REQUEST

Current Zoning: N1-A (neighborhood 1-A)
Proposed Zoning: UR-2(CD), 5-year vested rights (urban residential, conditional)

Approximately 53.07 acres located on the east side of Elm Lane and west side of Rea Road, south of Bevington Place.

The petition proposes to develop a residential community containing multi-family, single family attached and detached dwellings on the site currently developed with one single family dwelling in south Charlotte.

**REZONING SITE PLAN**  
 PETITION NO. RZP-2022-121

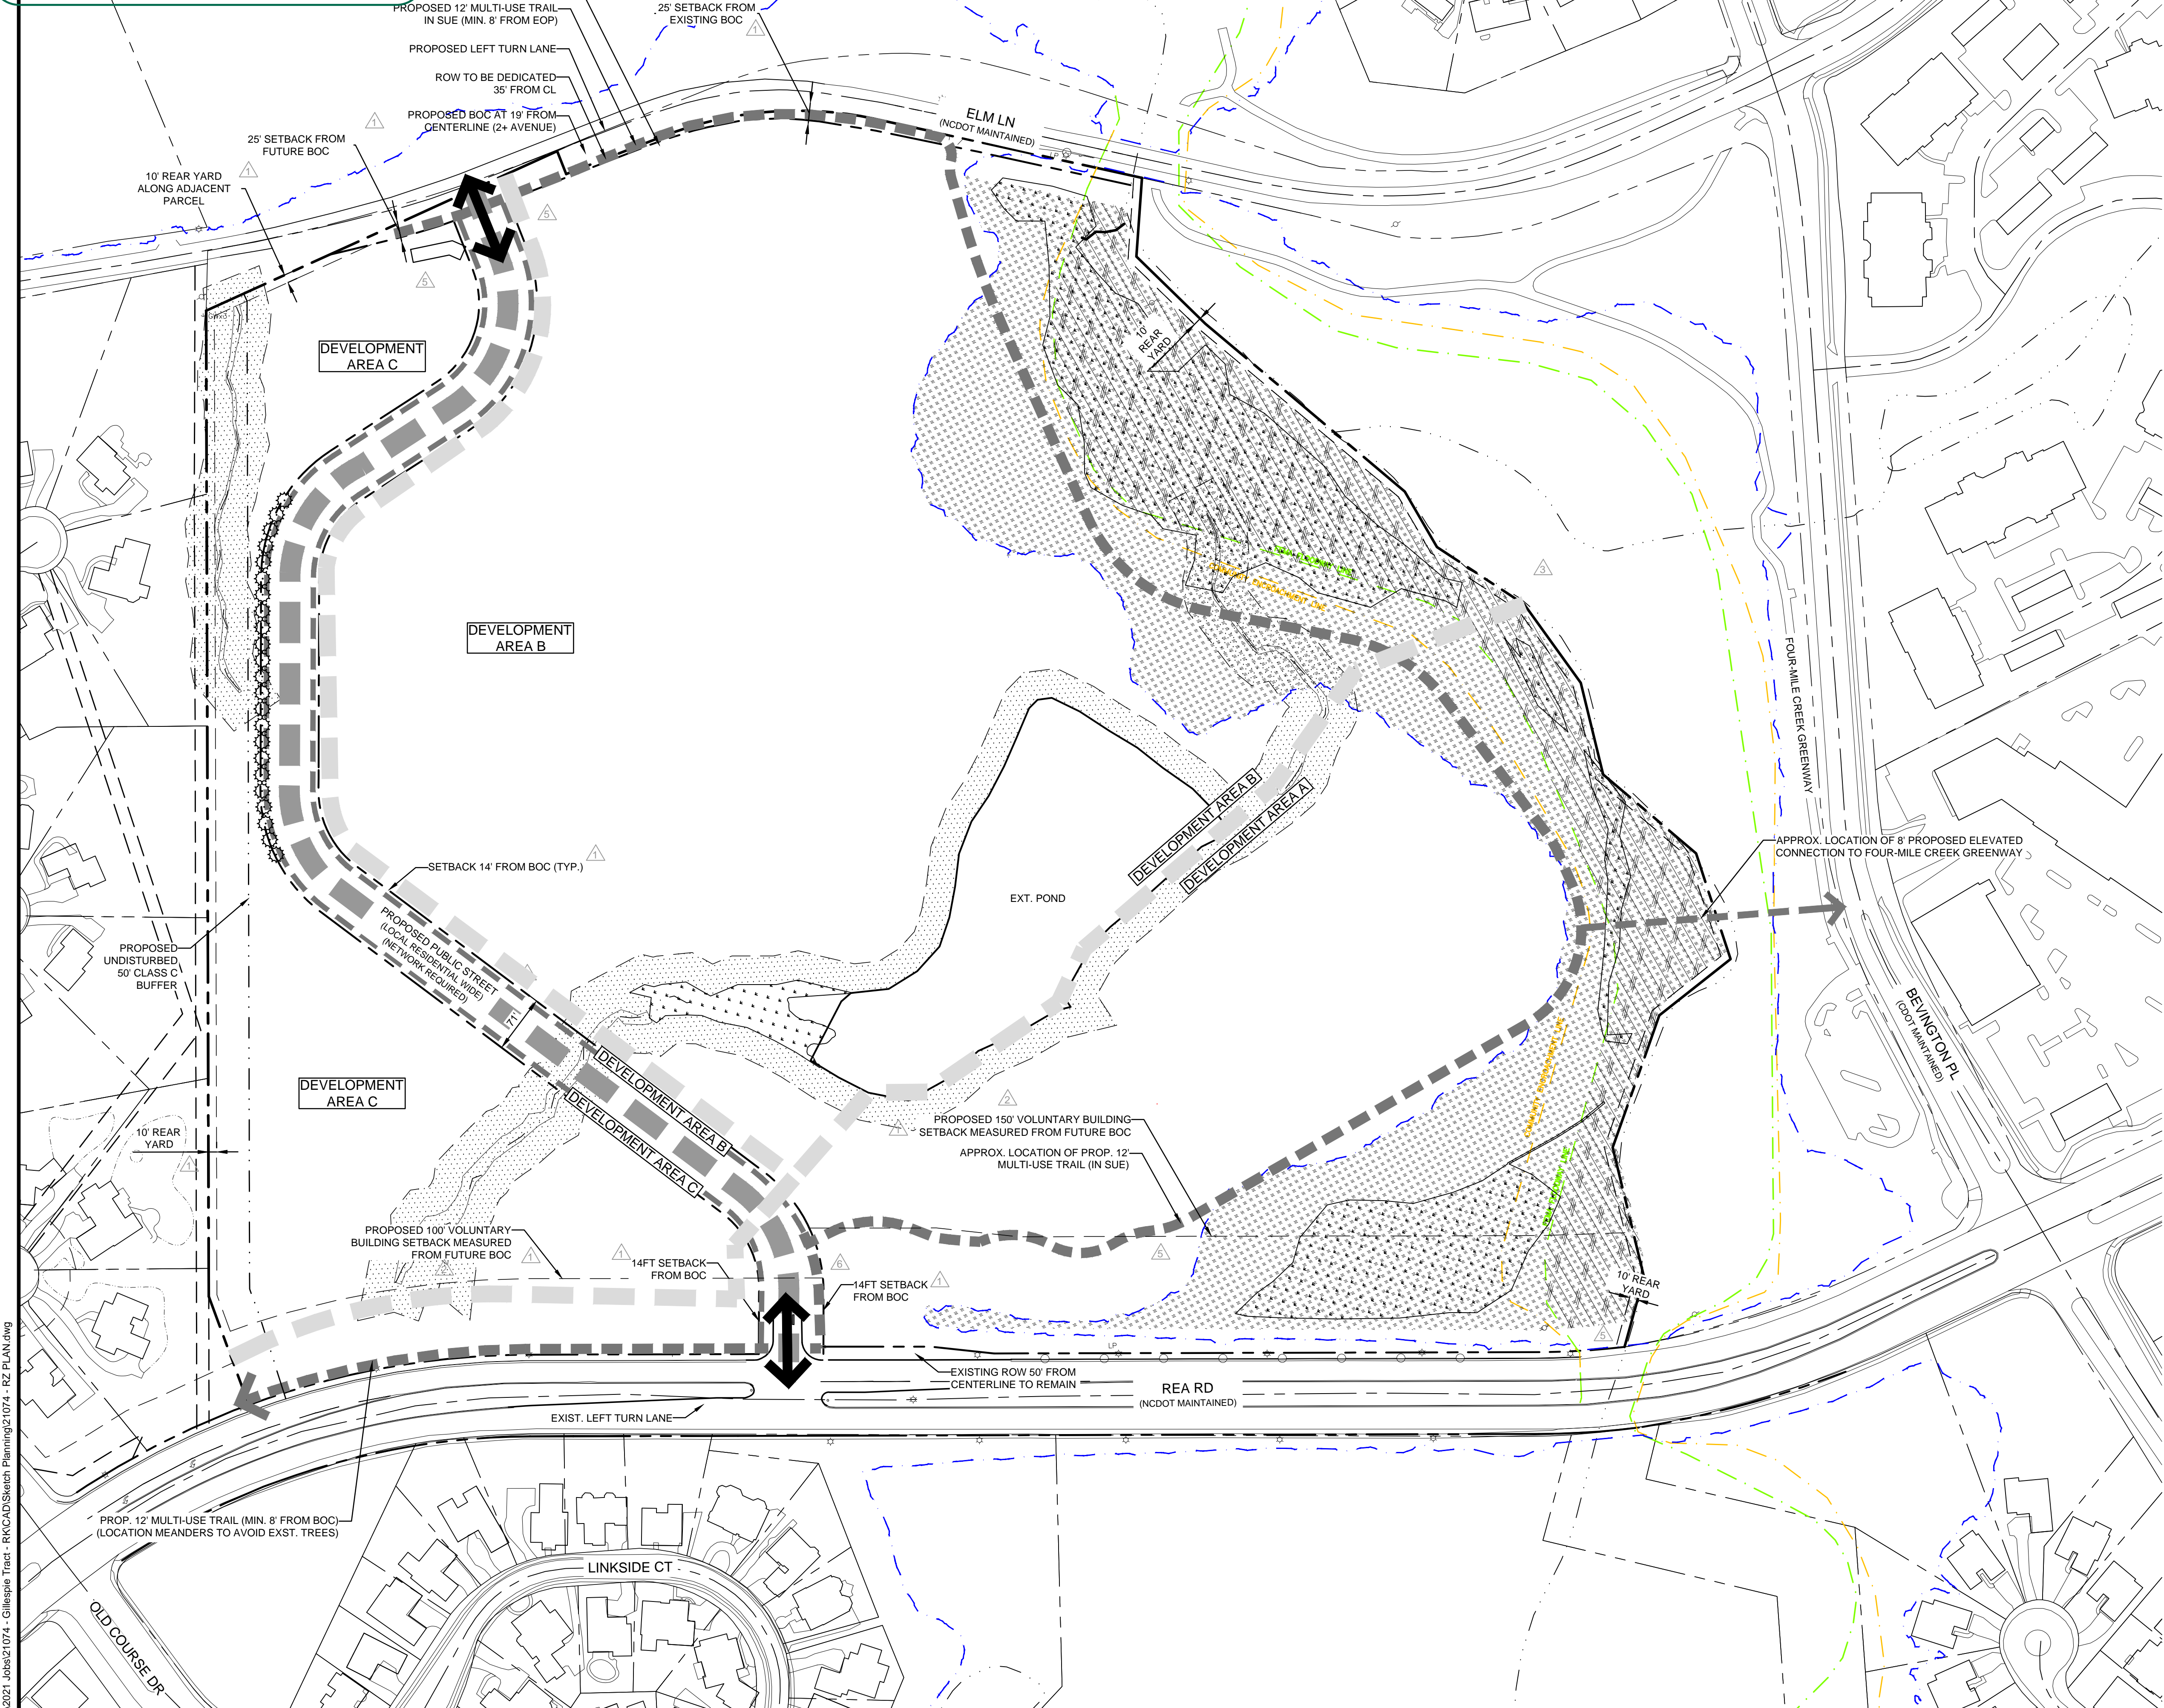
3. Reorient the building between the Pvt Alley and Rea Rd. south of the proposed street so that fronts Rea Rd. **Addressed the petitioner is providing landscape screening along the Pvt Alley.**

4. Relocate proposed parking area at the southeast corner of the intersection of Elm Ln and the proposed public street so that it is internal to the development. **Addressed.**

5. Relocate proposed parking area at the northwest corner of the intersection of the proposed public street and Pvt Alley so that it is internal to the development. **Addressed**

6. Clarify how pedestrian connection will be made from Rea Rd. to the proposed internal 12' multi-use path. **Addressed.**
7. Remove/modify notes 3.2.3 and 3.2.4 to clarify that additional multi-family units would not replace single family attached units shown on the plans. **Addressed**

1 EASTERN SECTION  
RZ-5 SCALE: 1" = 40'

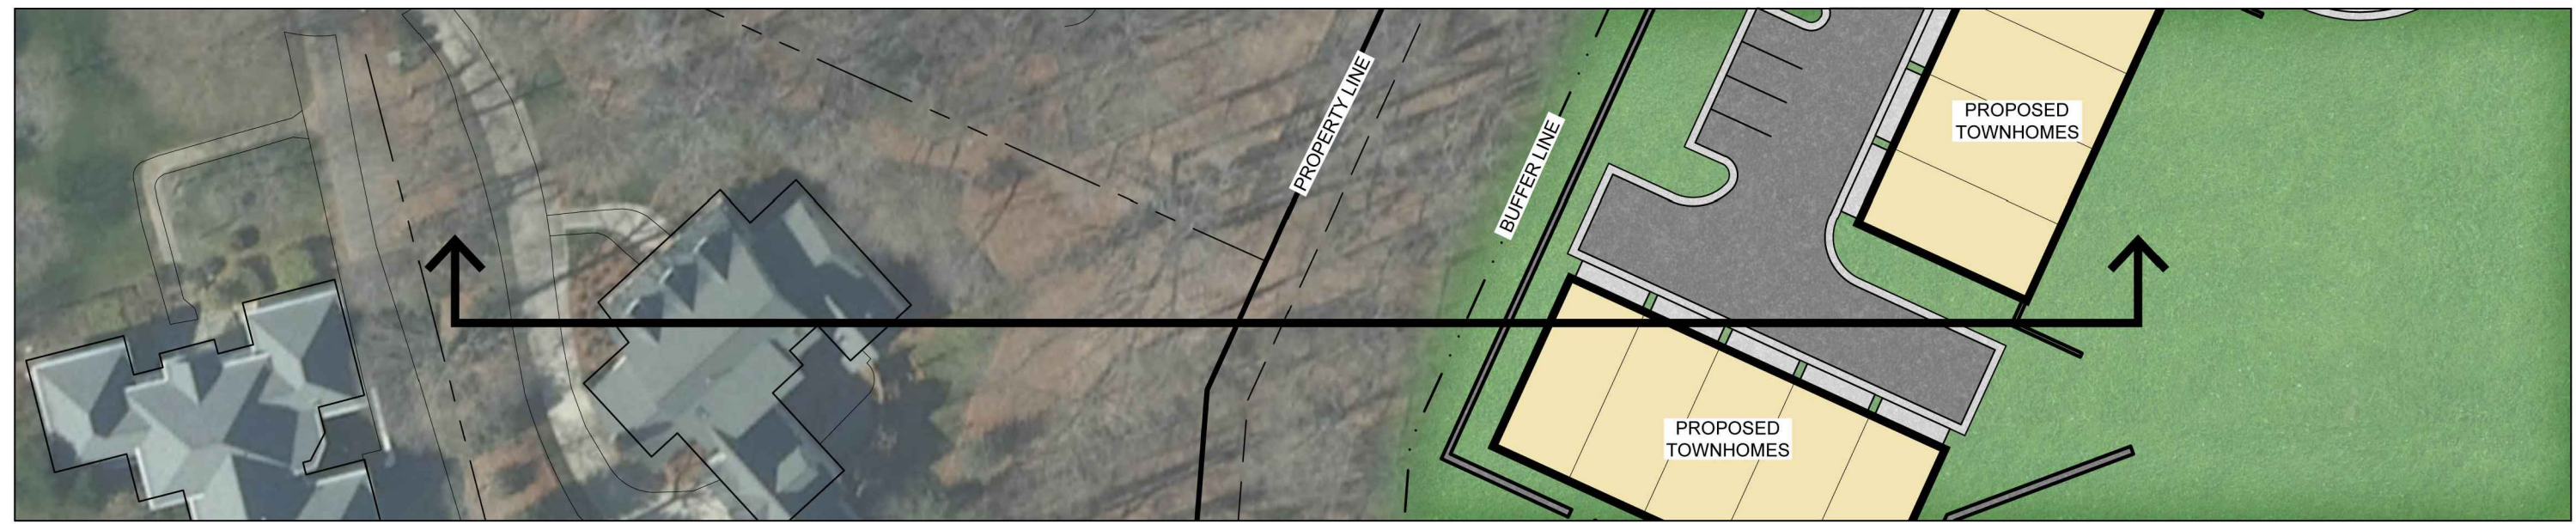
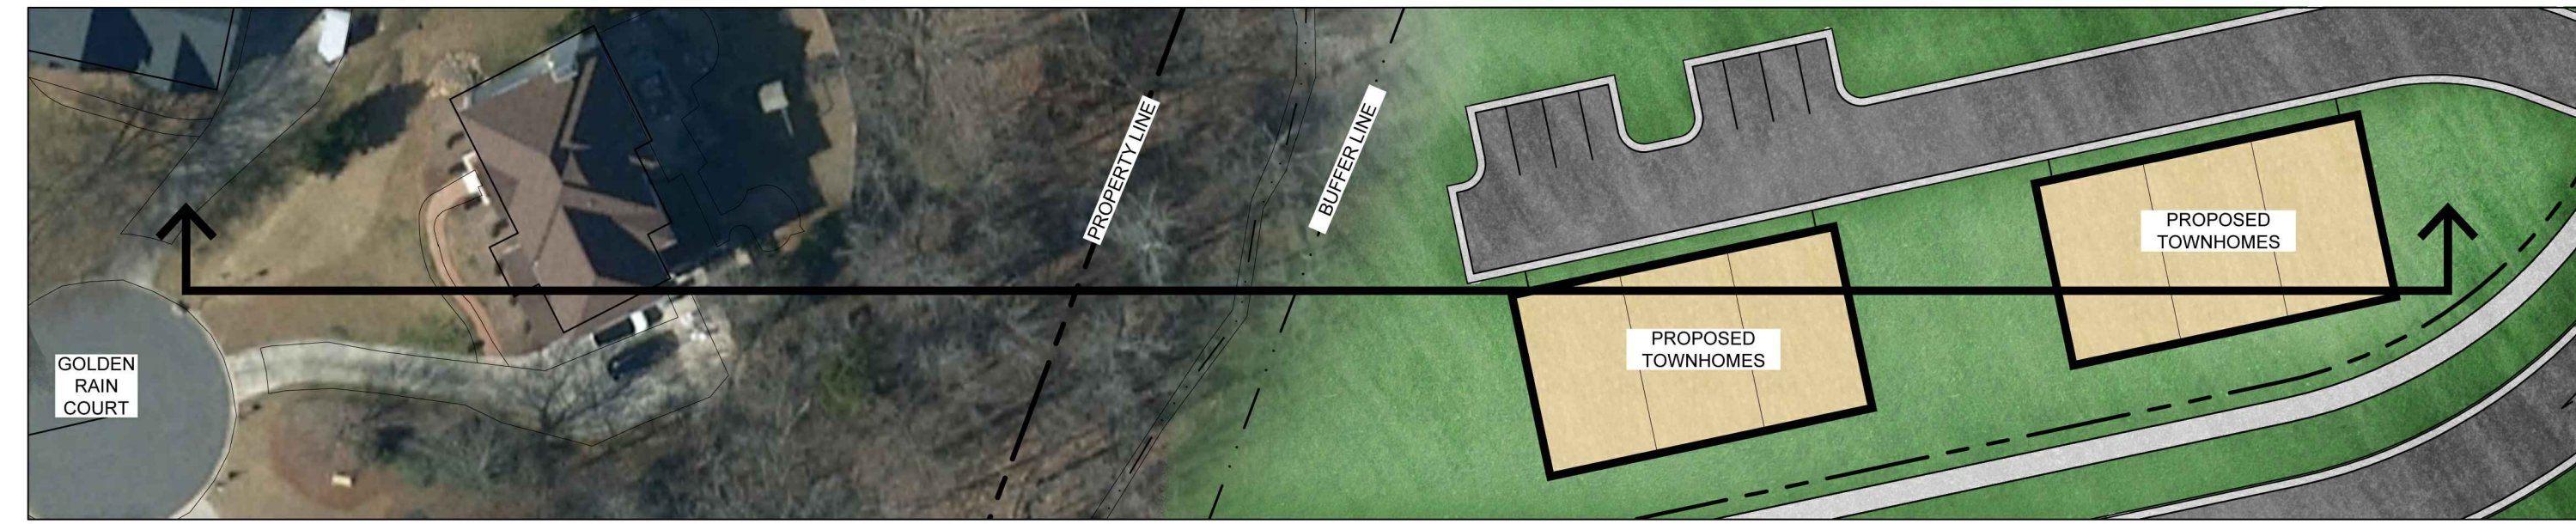
- Constructs an 8 ft wide planting strip and 12 ft multi-use path along the site frontage on Rea Rd. located south of the internal east/west public street. The multi-use path may meander to preserve existing trees. (6.1)

- Constructs an 8 ft wide planting strip and 12 ft multi-use path along the site frontage on Elm Ln. north to approximately the 100 year flood plain. The multi-use path may meander to preserve existing trees.
